# GRADING AND EROSION CONTROL PLAN

### SECURITY WATER DISTRICT

# WATER TREATMENT PLANT BUILDING ADDITION

## AUGUST 2024 (AMENDED JANUARY 2026)

**SITE GRADING, DRAINAGE, LANDSCAPING, AND EROSION CONTROL PLAN AND TREATMENT PLANT BUILDING ADDITION**  
SECURITY WATER DISTRICT

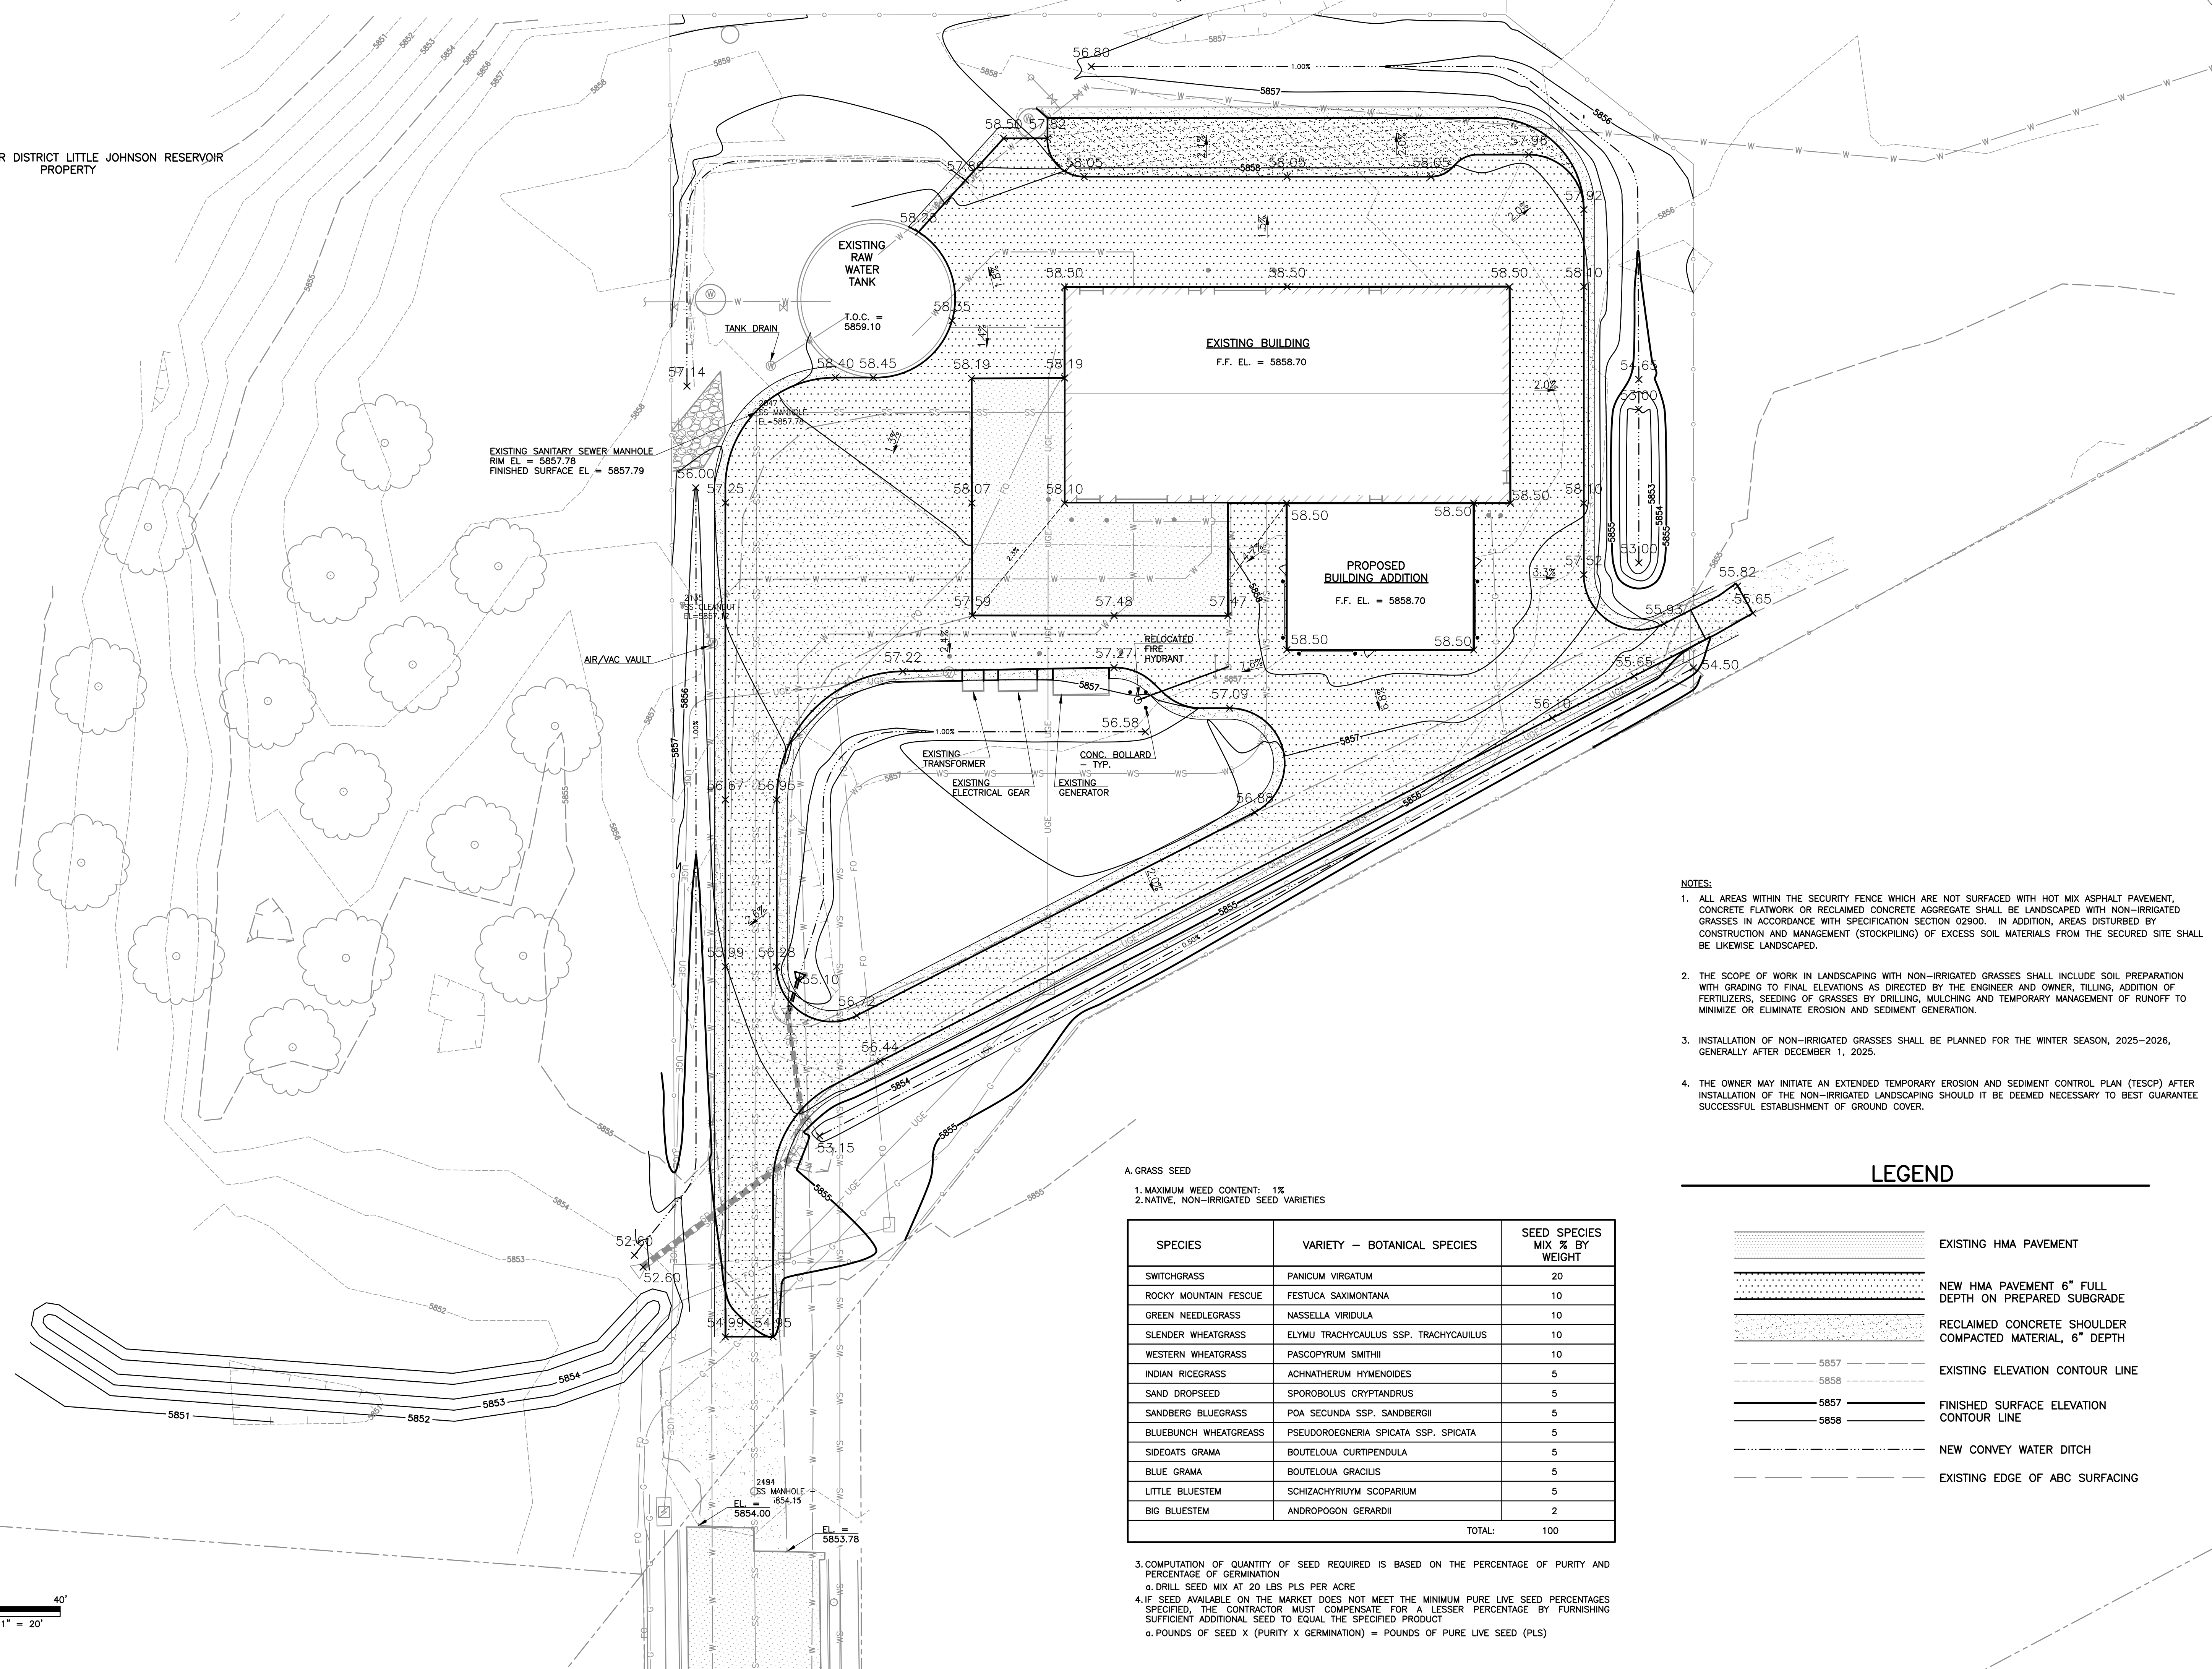
Wattles are temporary control measures and should not be left in field permanently. If permanent check dams are necessary consider riprap check dams, otherwise specify that wattles are an interim measure to be removed for final condition.

Initial or interim?

Provide construction details for all temporary control measures. EPC details can be found in EPC DCMv2 Ch 3.
